Appeal Decision

Appeal Ref: APP/R5510/D/25/3359423

27B Church Road, Hillingdon, UB8 3NB.

- The appeal is made under section 78 of the Town and Country Planning Act 1990 (as amended) against a refusal to grant planning permission.
- The appeal is made by Mr G Bourton against the decision of the London Borough of Hillingdon Council.
- The application Ref is 2202/APP/2024/2331.
- The development proposed is the erection of a single-storey part rear extension.

A103

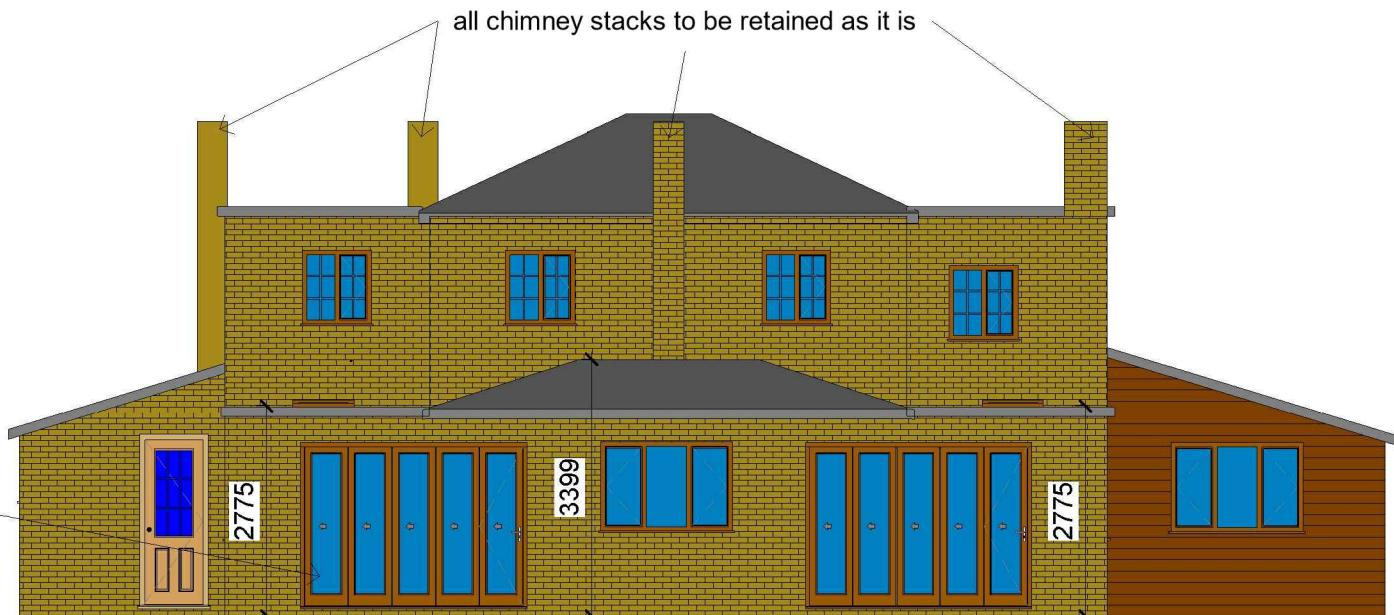
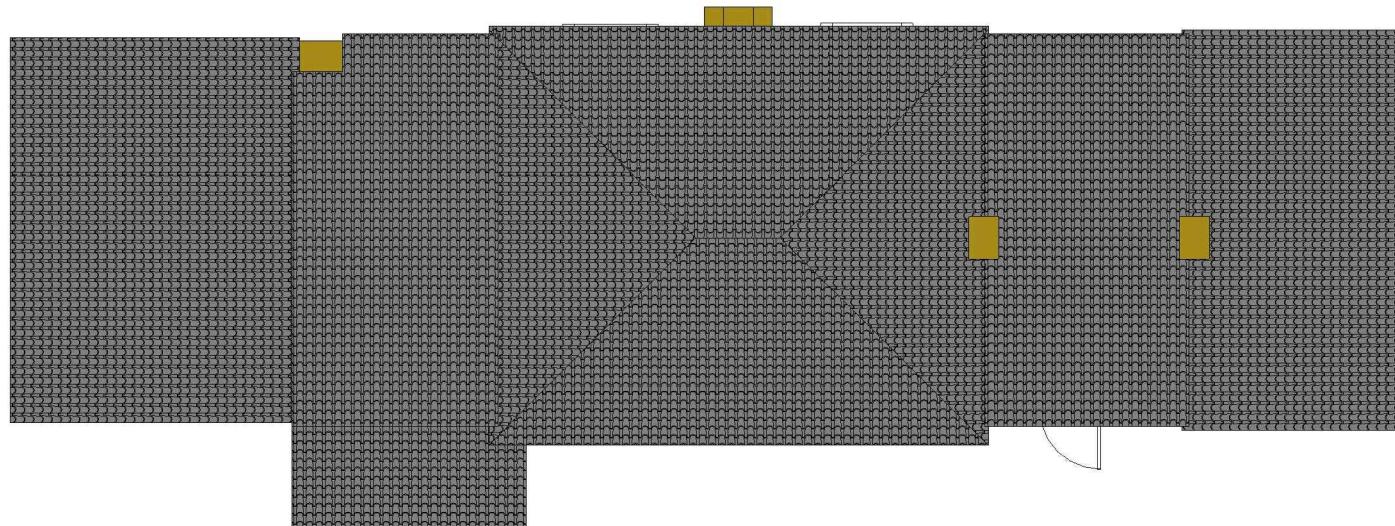
4. With a depth of 4m and a maximum height of 3.4m the extension would conform to the dimensional requirements of Policy DMHD1 of the adopted Hillingdon Local Plan (HLP). The roof profile would closely reflect that of the existing main construction, and the finishing materials and fenestration, when secured by condition, would match or complement those of the present elevations.
